Final Plat - Comment Response Letter

Citizen on Constitution  
El Paso County, Colorado

PCD File Number: SF-226

**AKERS DRIVE CD'S – PCD ENGINEERING  
COMMENT RESPONSE**

- TRUCK TIRE TRACKING OFFSET
- TRUCK BODY TRACKING OFFSET

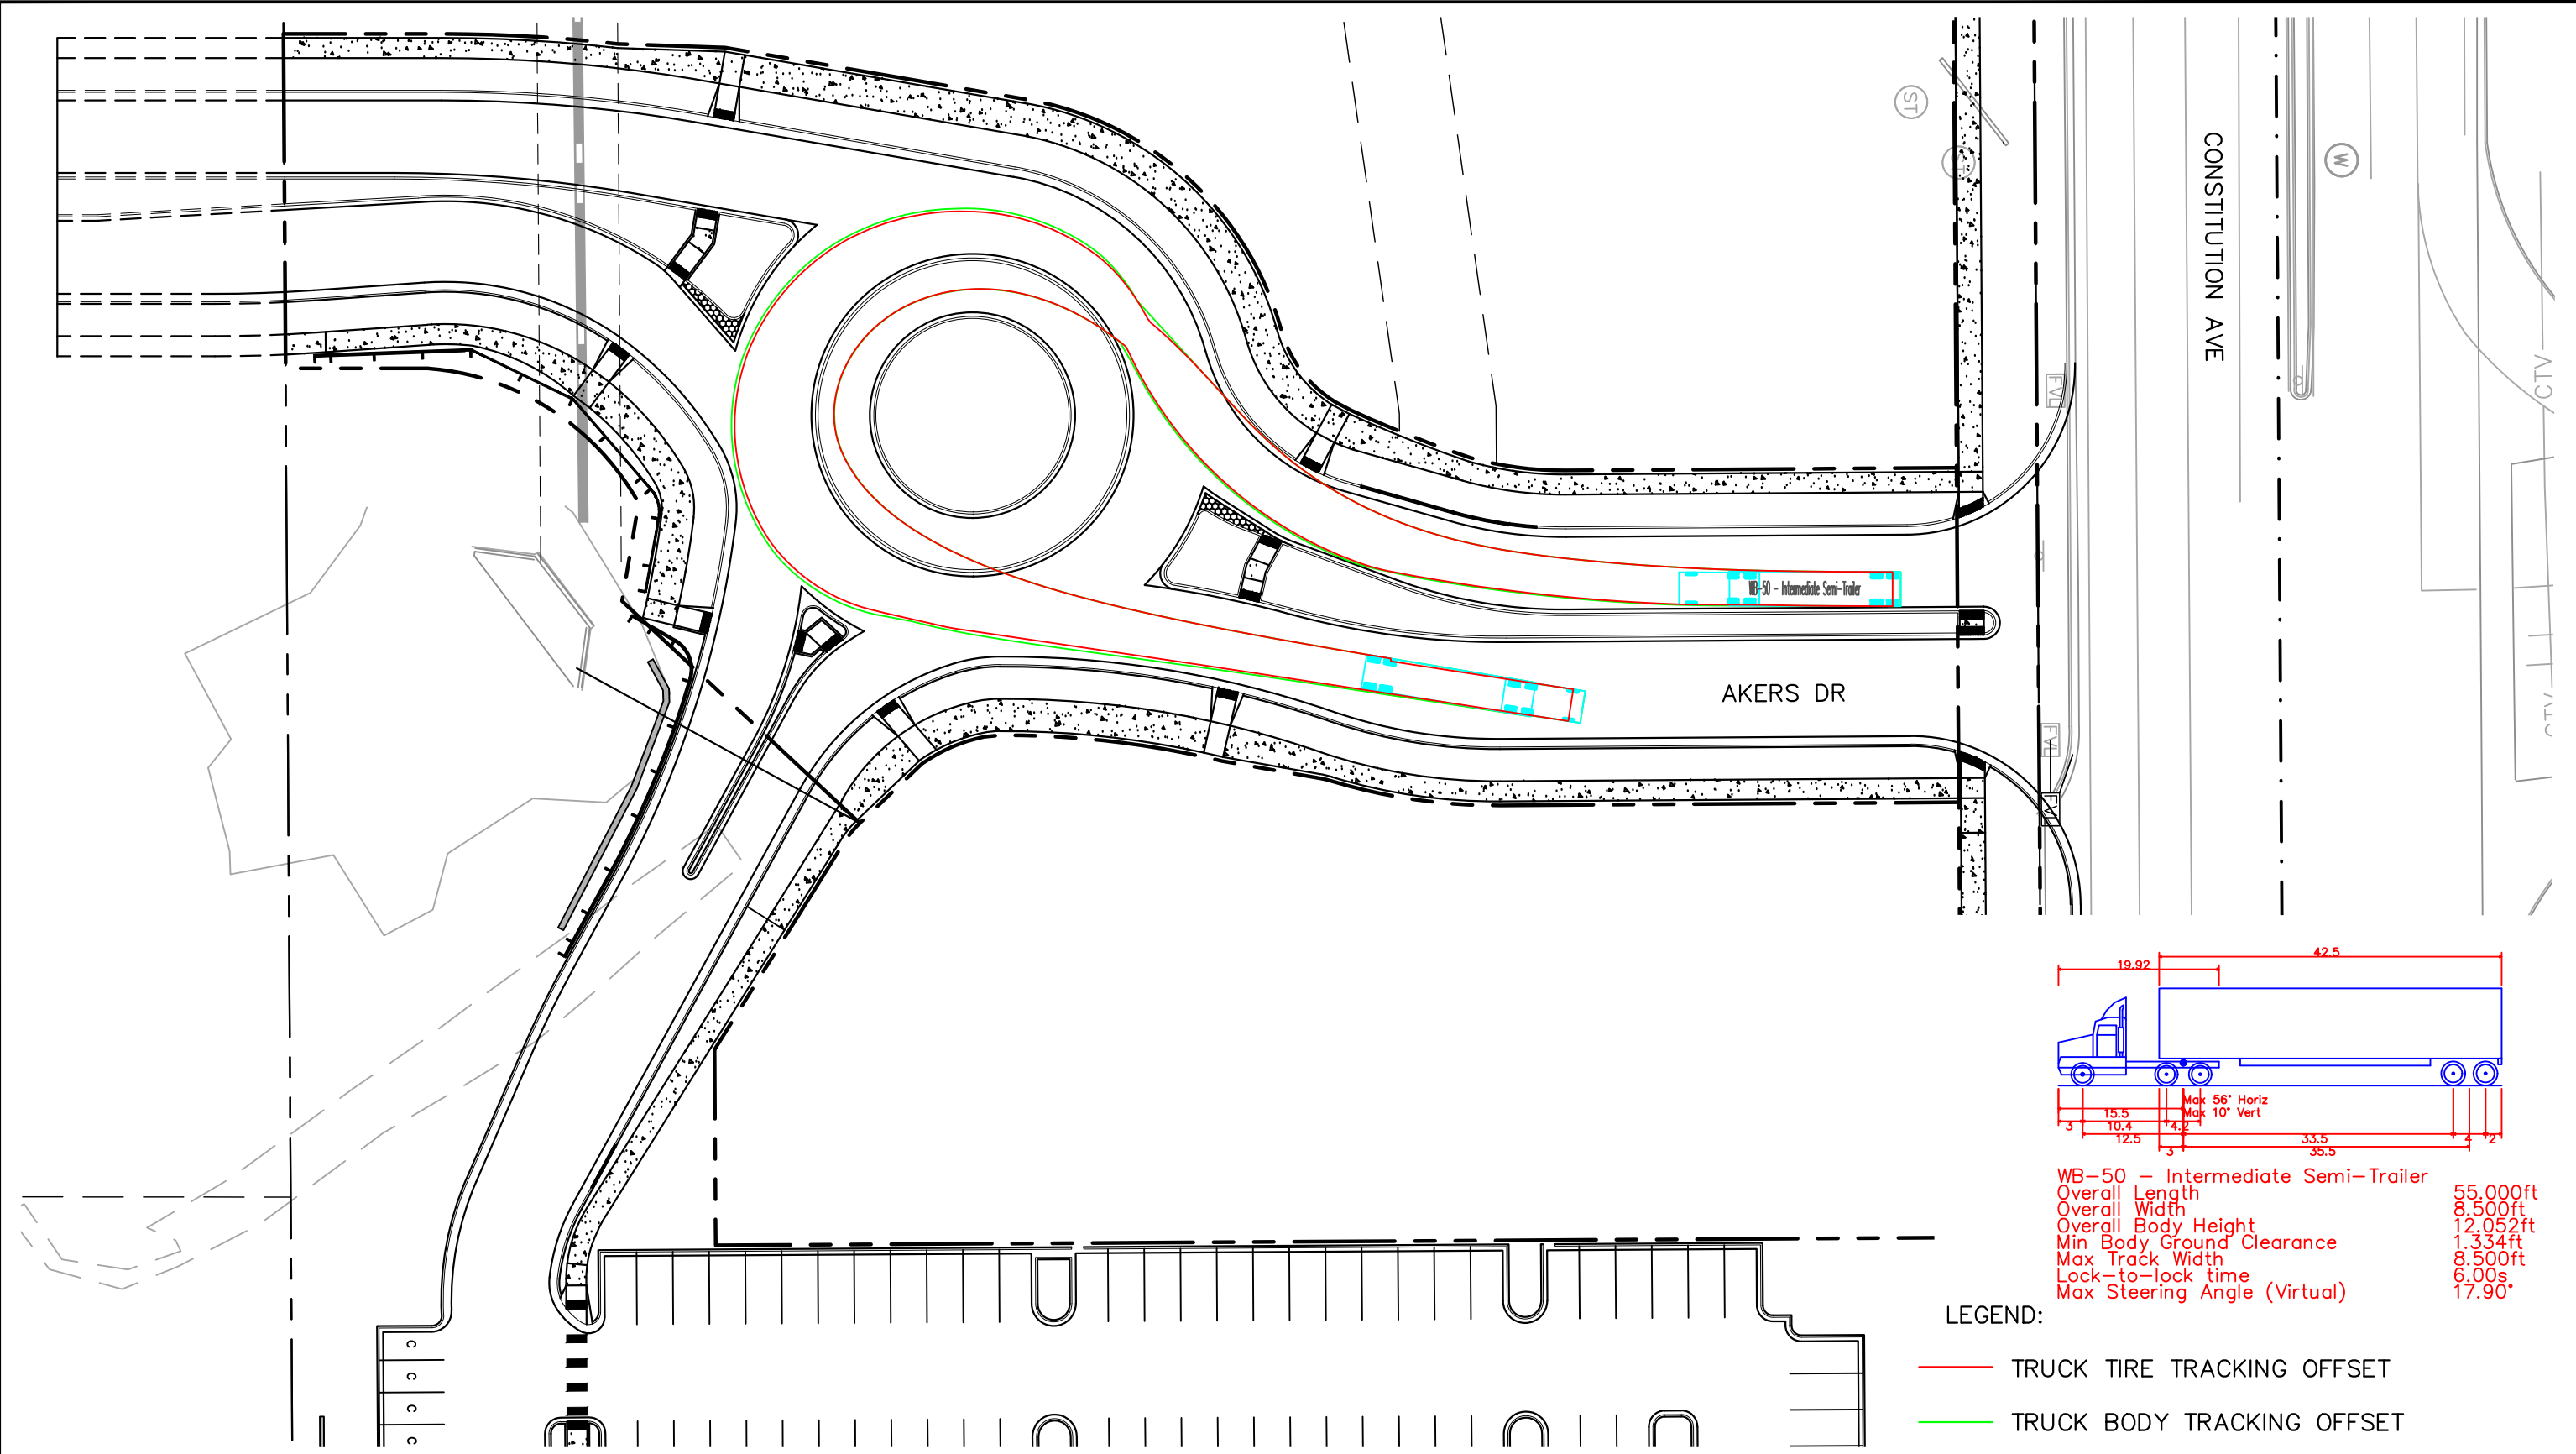
Please revise from snow plow to the WB-50 vehicle

UPDATED TO WB-50 VEHICLE

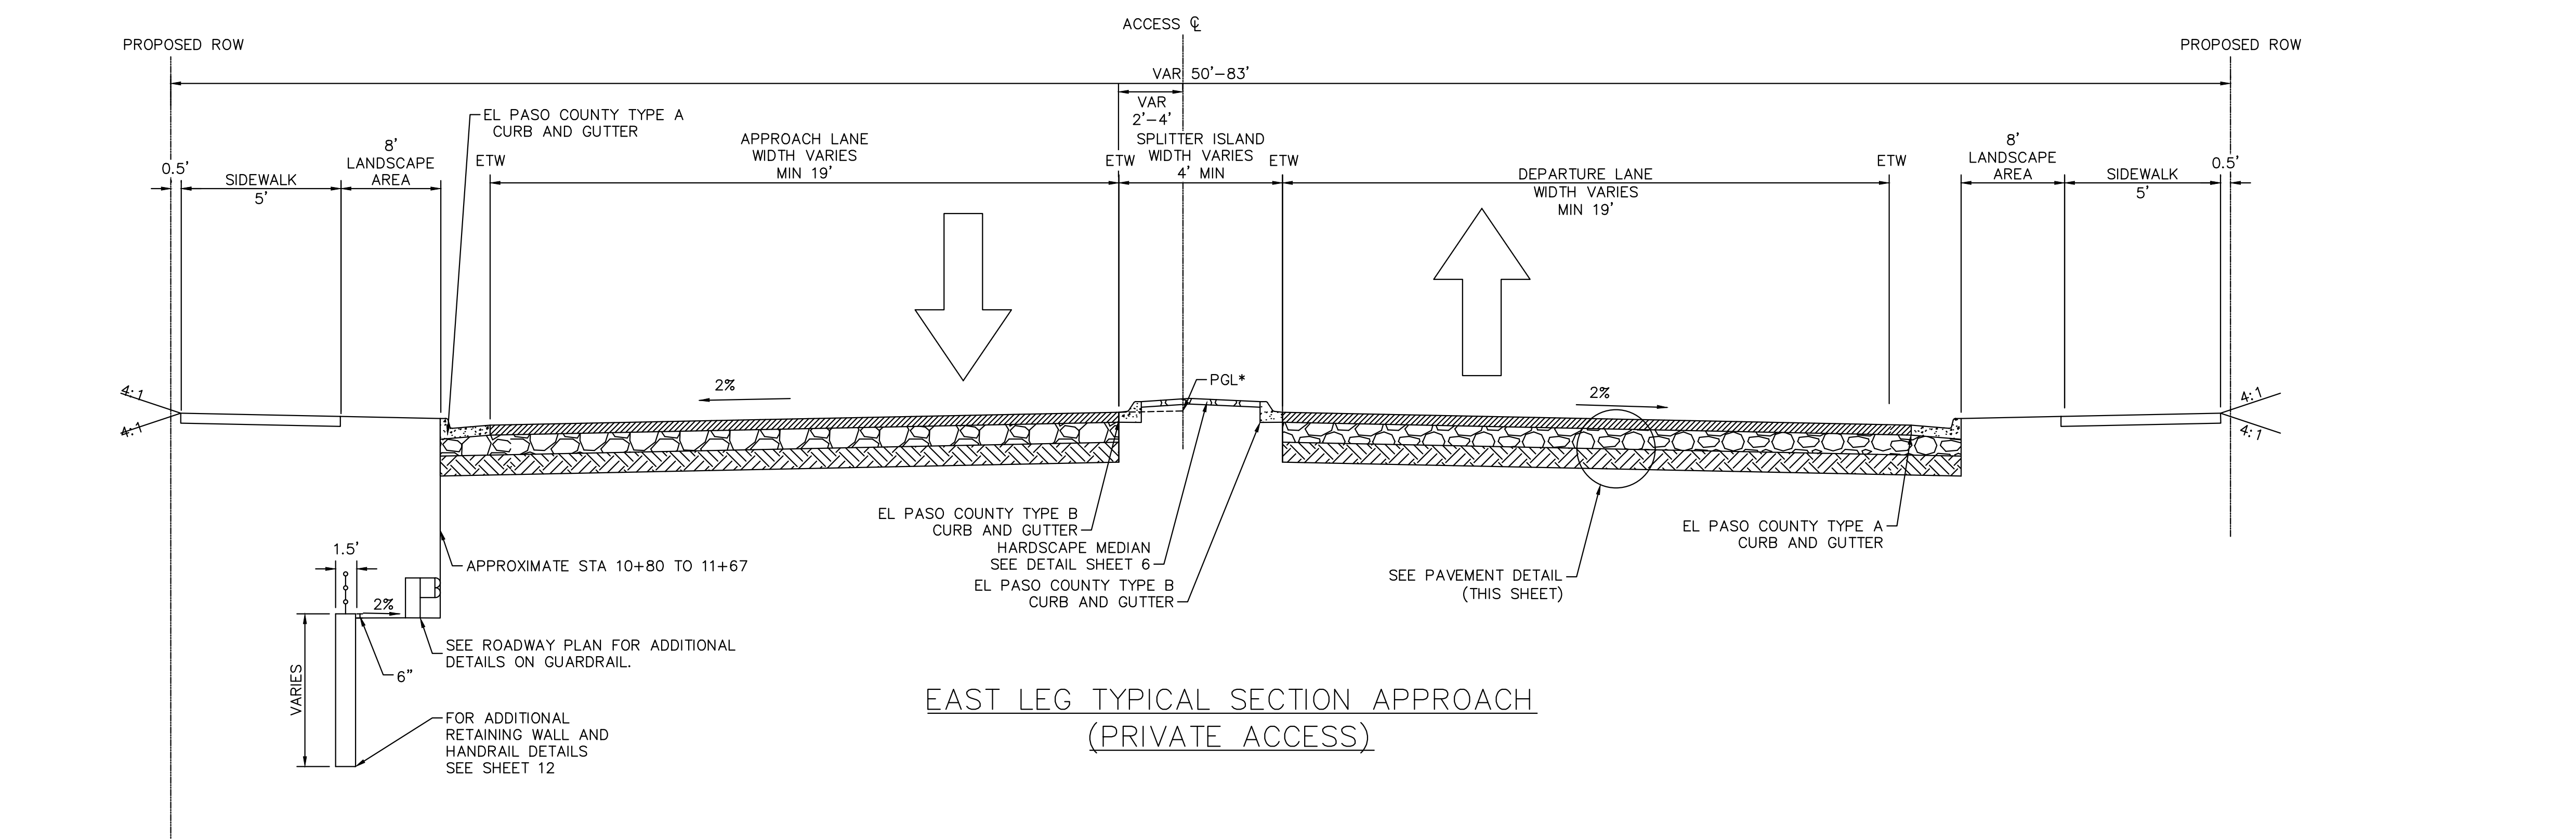
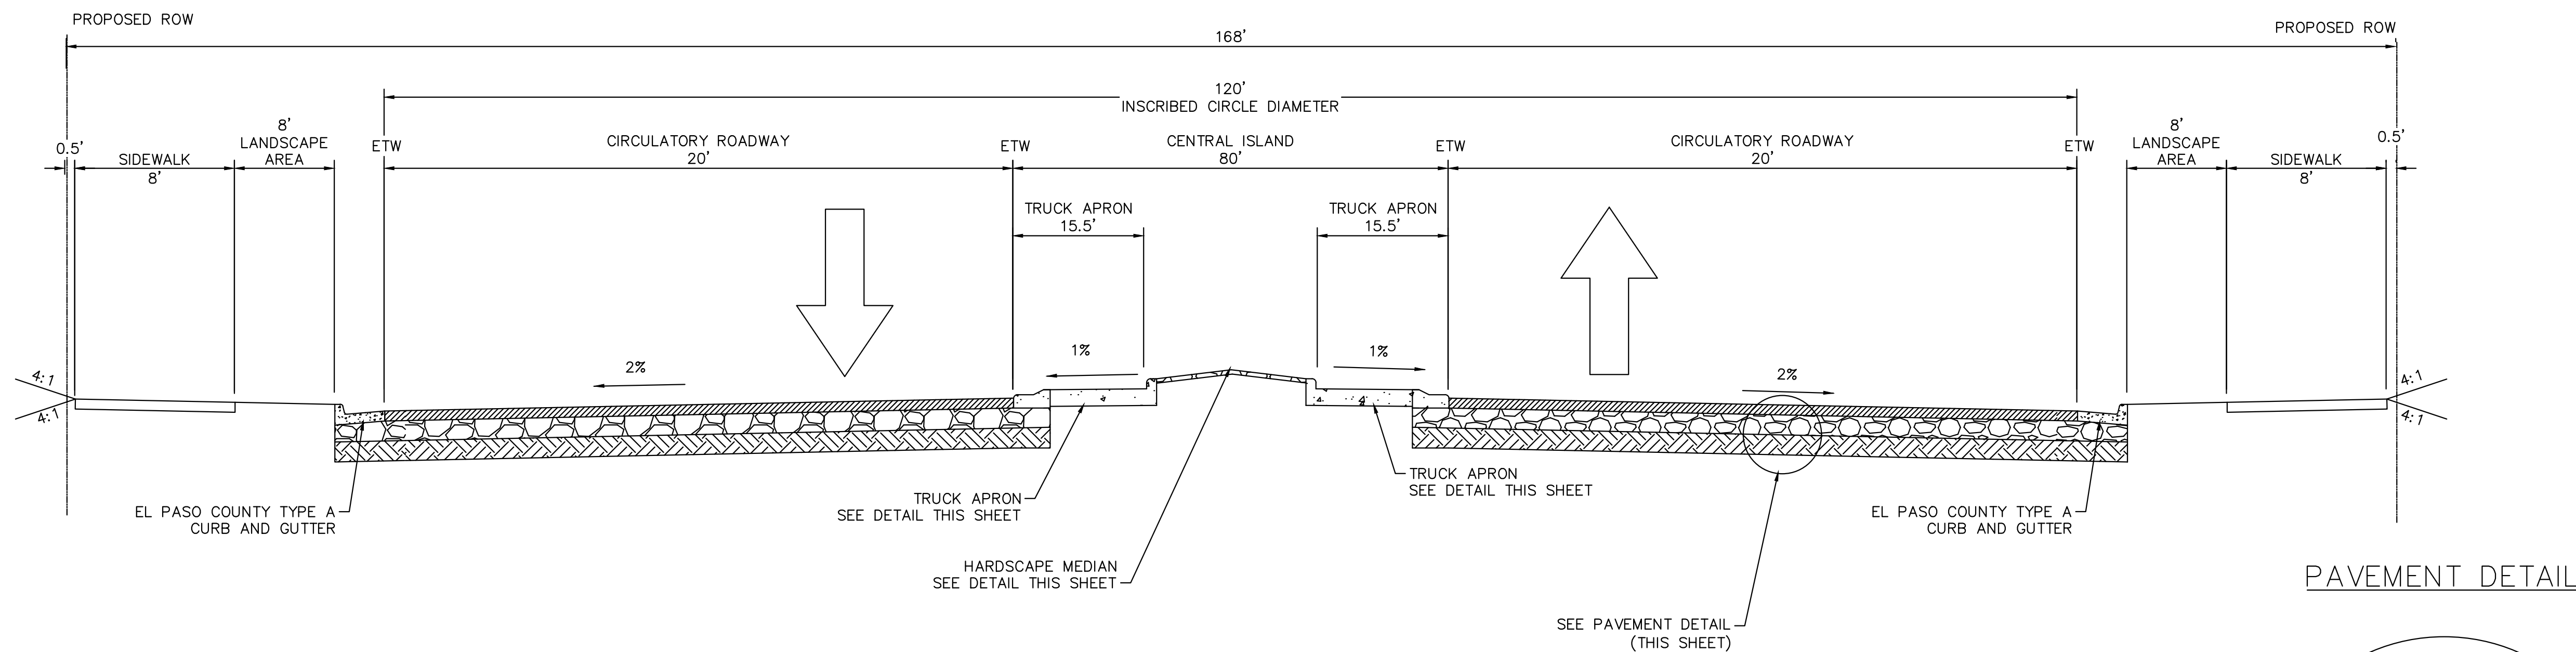
Please identify that these values are for bid purposes only and that a pavement report shall be submitted to the County for review and approval.

ROW width shall be 80' min. per the roadway classification. Revise

**PAVEMENT DETAIL UPDATED.**

ROW WIDTHS UPDATED ACCORDINGLY
